# ENG-PUDSP20005-R2-MDDP-redlines.pdf Markup Summary

. Master Development Drainage Plan – Bent Grass  
Residential Subdivision, by Galloway &  
Company, May 2019.

| Stream Centerline | Existing Approximate 100-yr Floodplain* | Floodplain Study Limit | Inlet | Manhole | Pipe | | | | |

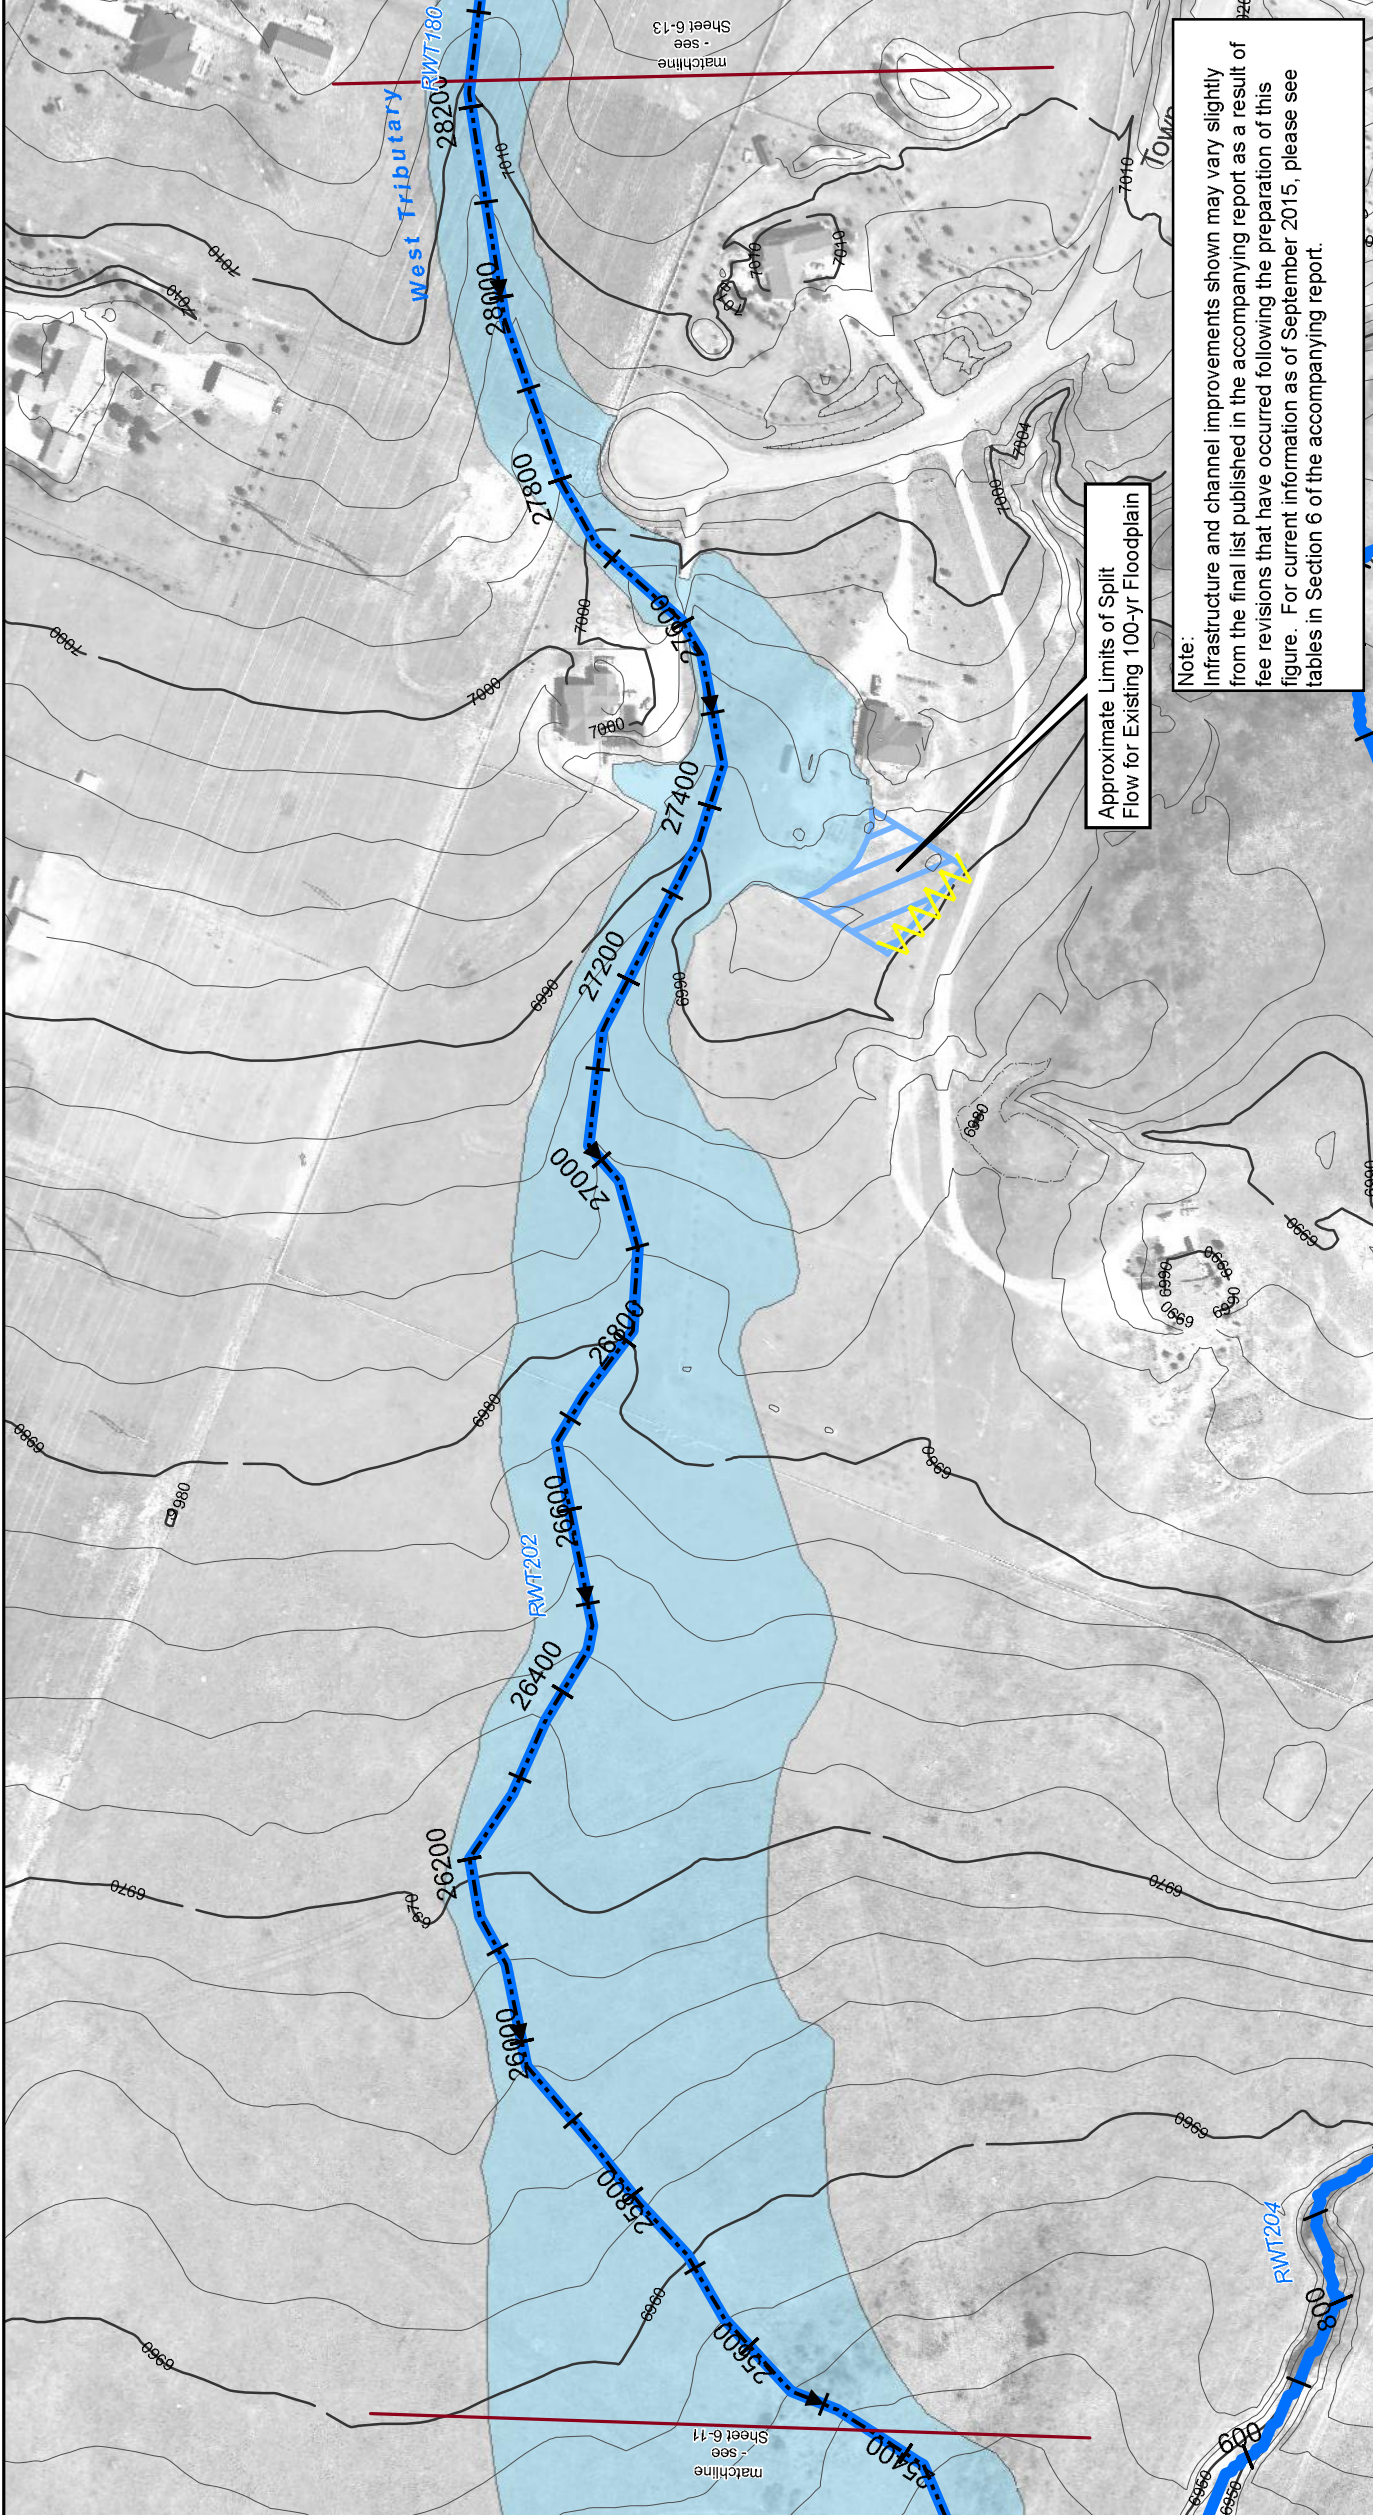
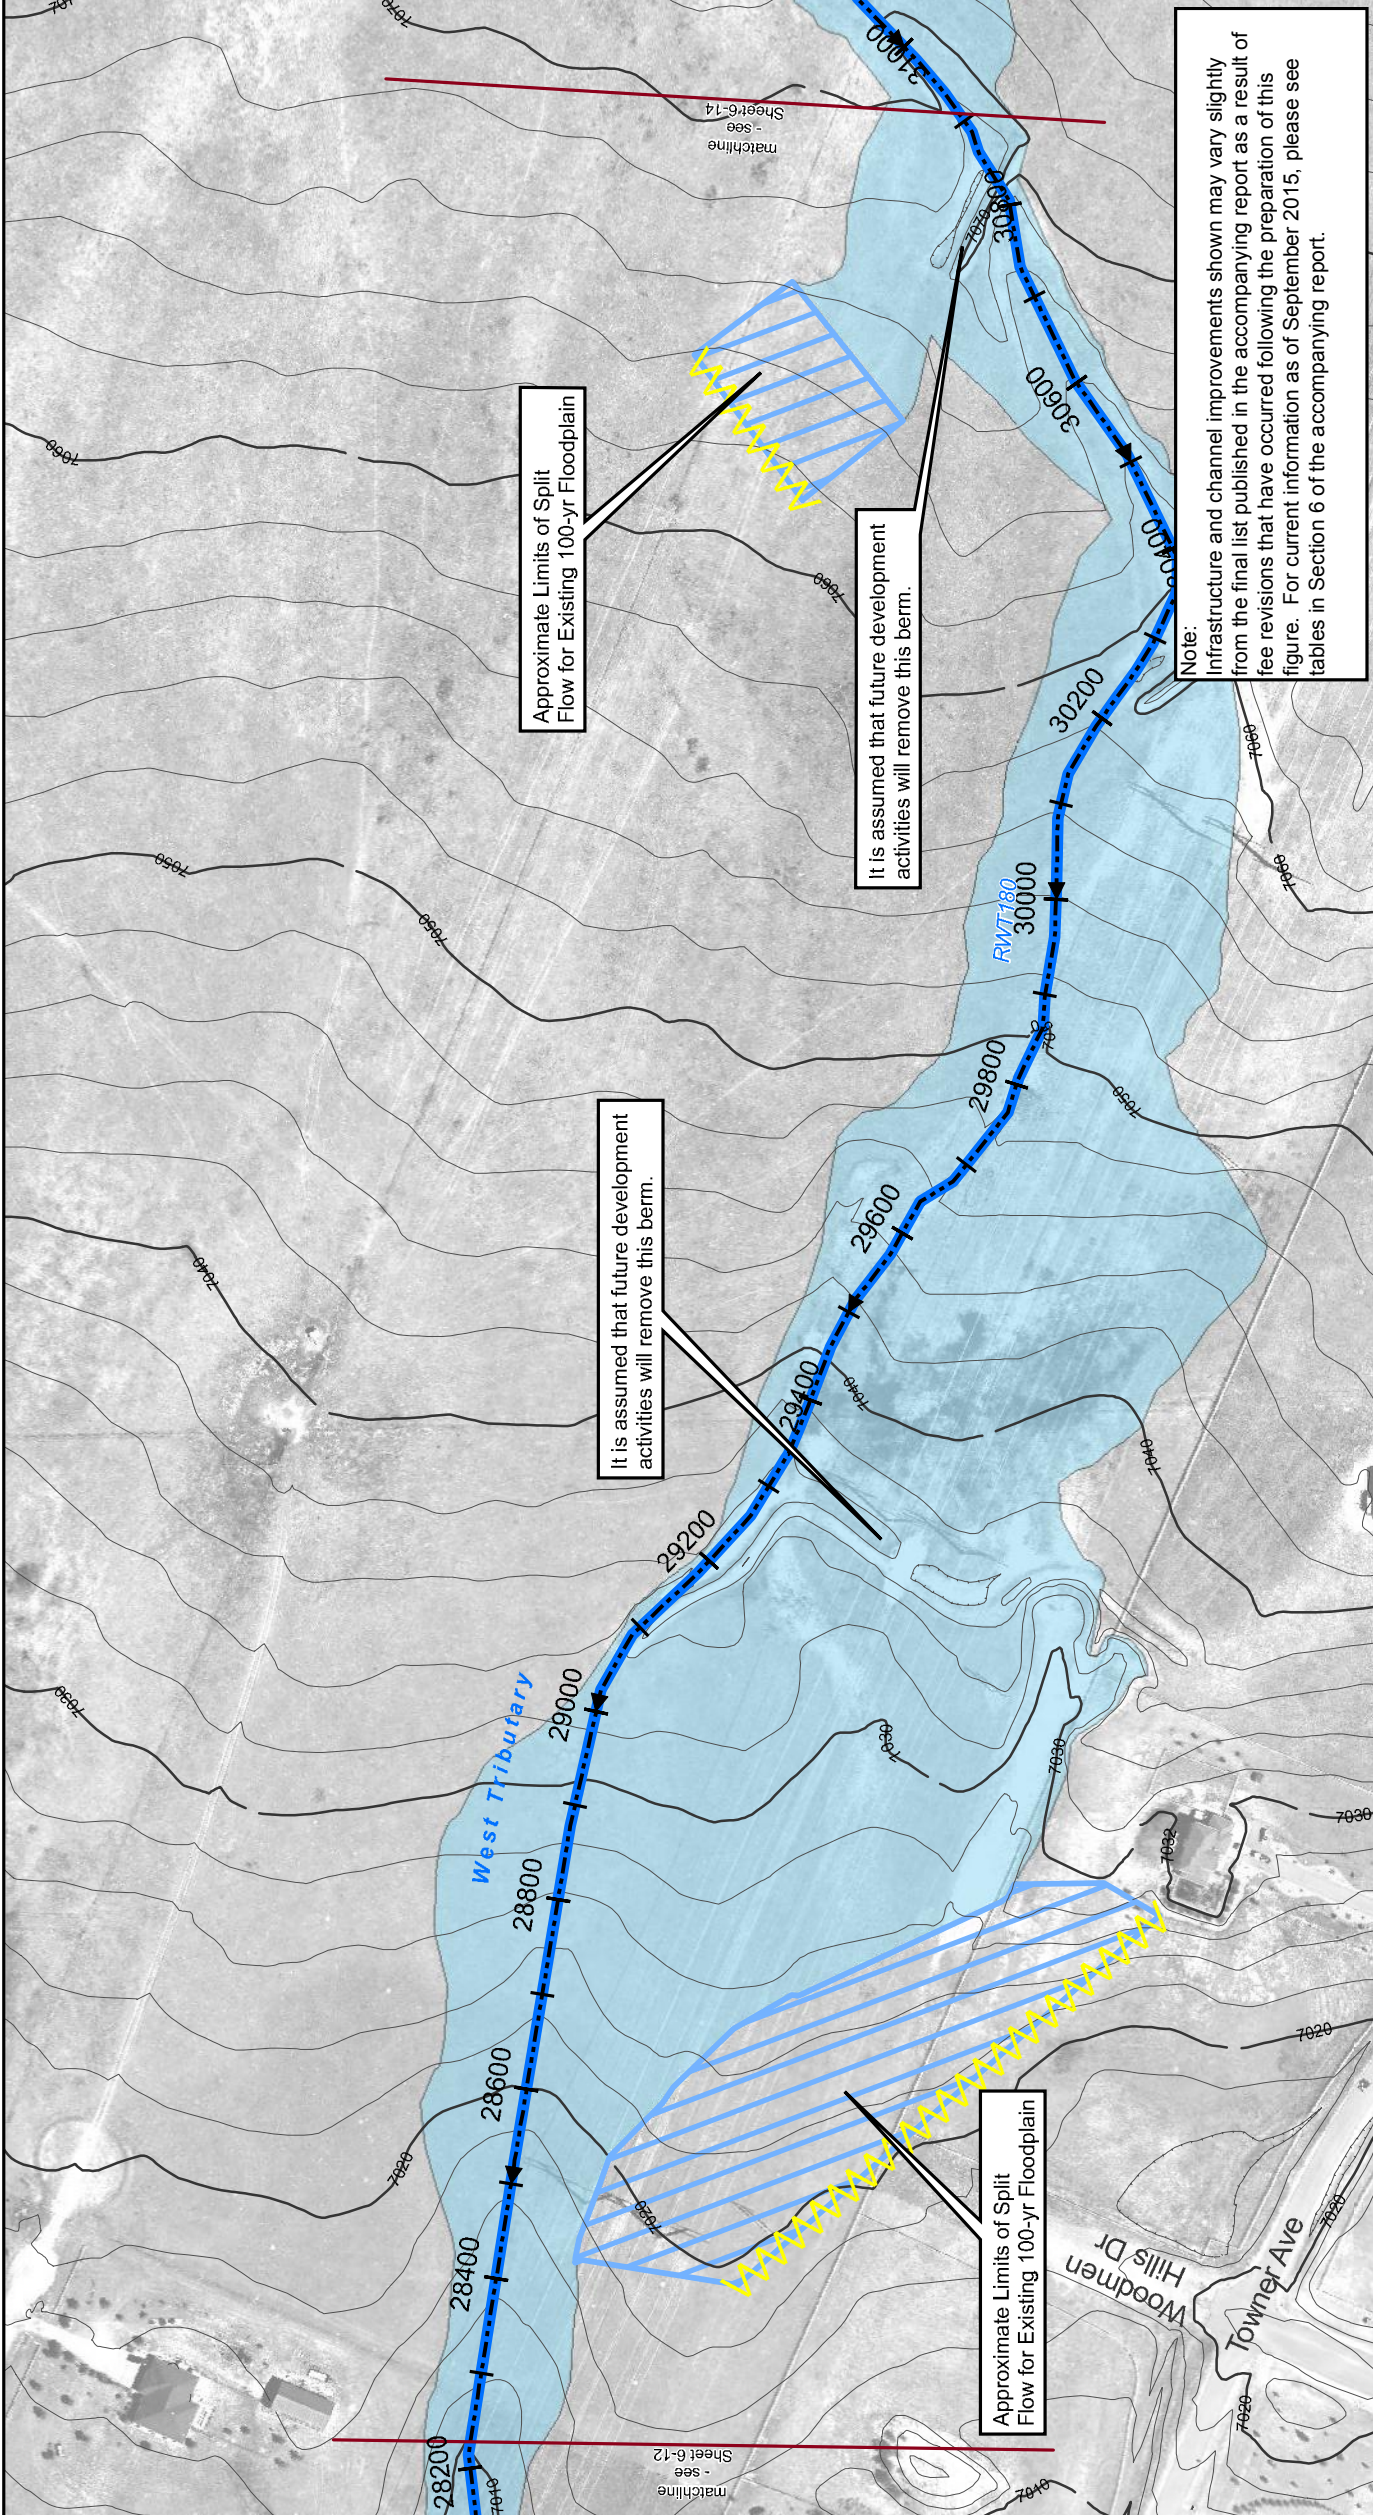
Provide conceptual channel plan and DBPS details for RWT 210

Figure 3-13  
Future Hydrology  
Falcon DBPS  
El Paso County, CO

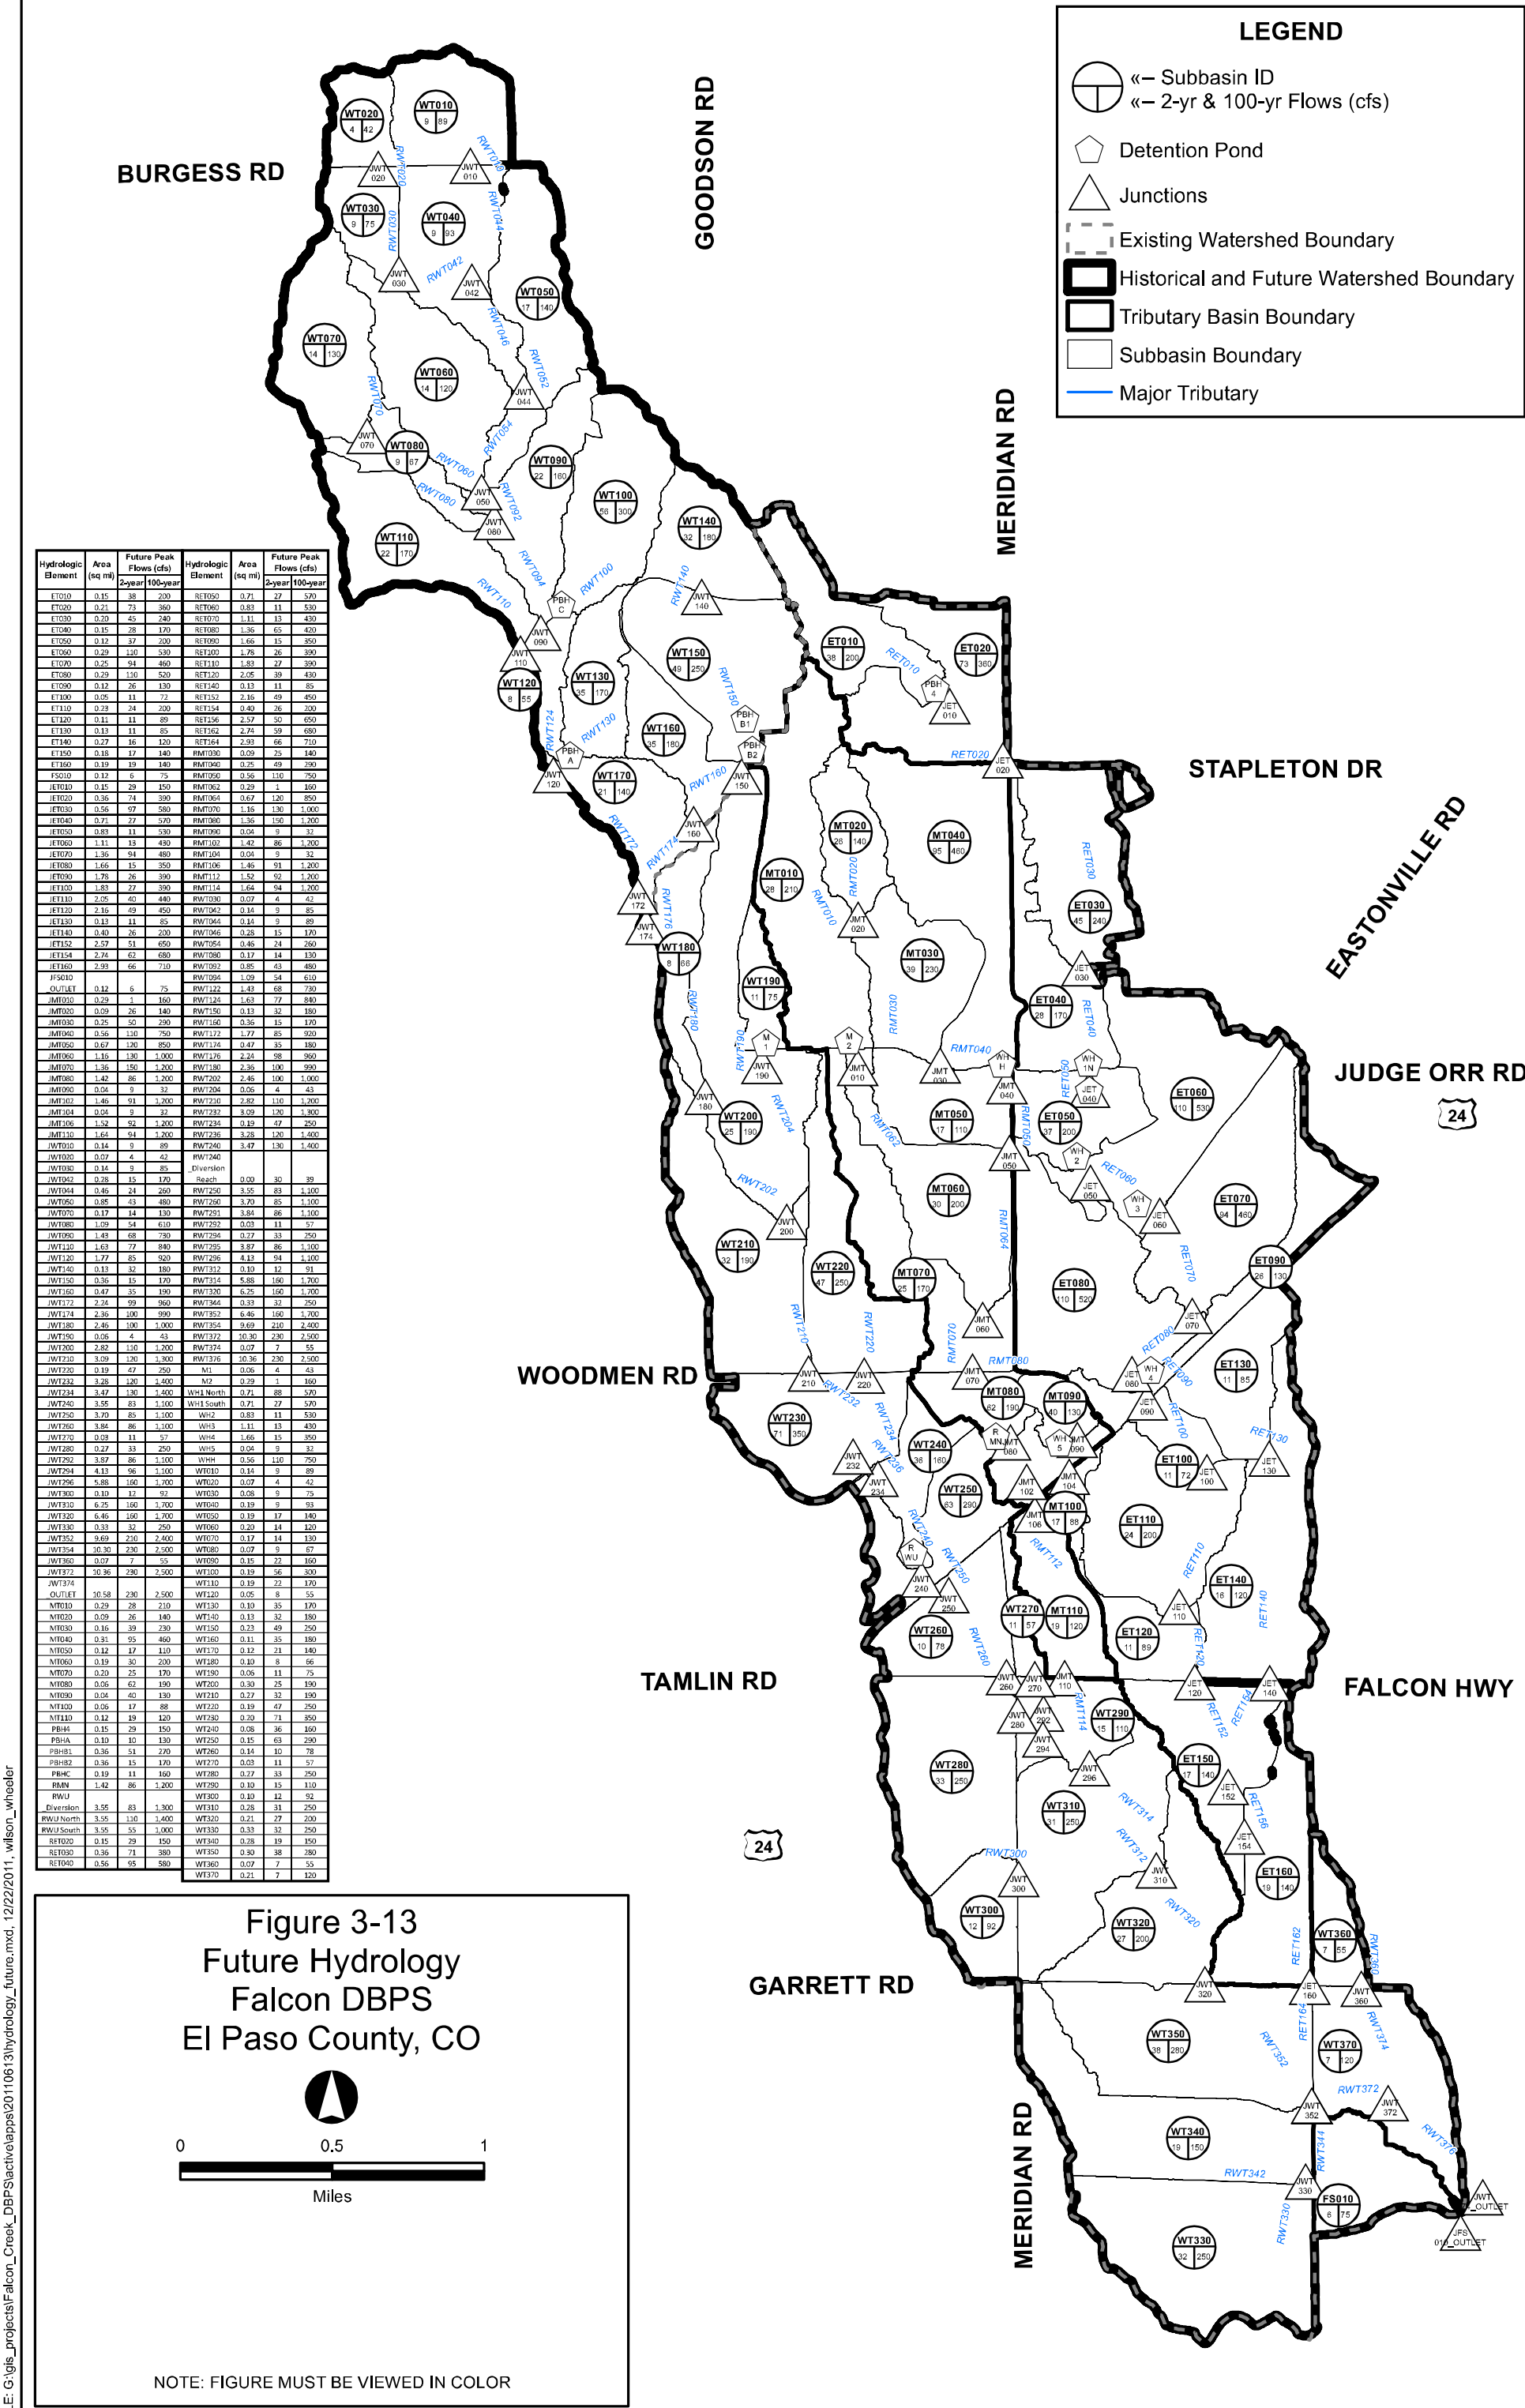
Replace Figure 3-13 (with prev. redlines) and add 3-12 if desired

Replace Figure 3-13 (with prev. redlines) and add 3-12 if desired
